# Markup Summary

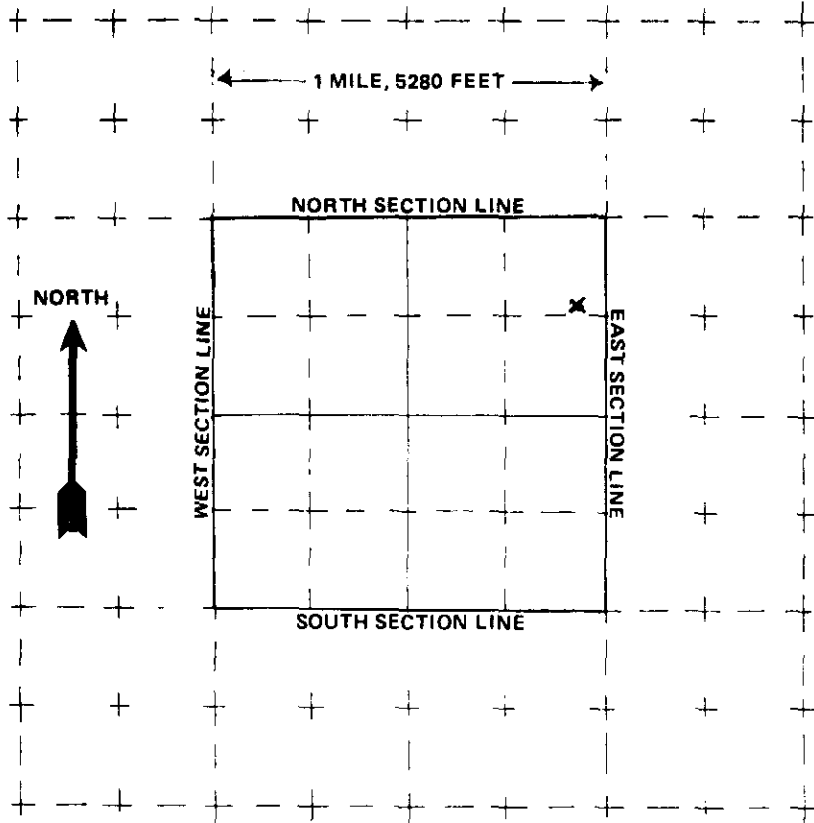
See Engineering notes, measurements to all property lines must be included and indicate which structures are existing.

Label areas for parking, and/or storage of non-operable vehicles
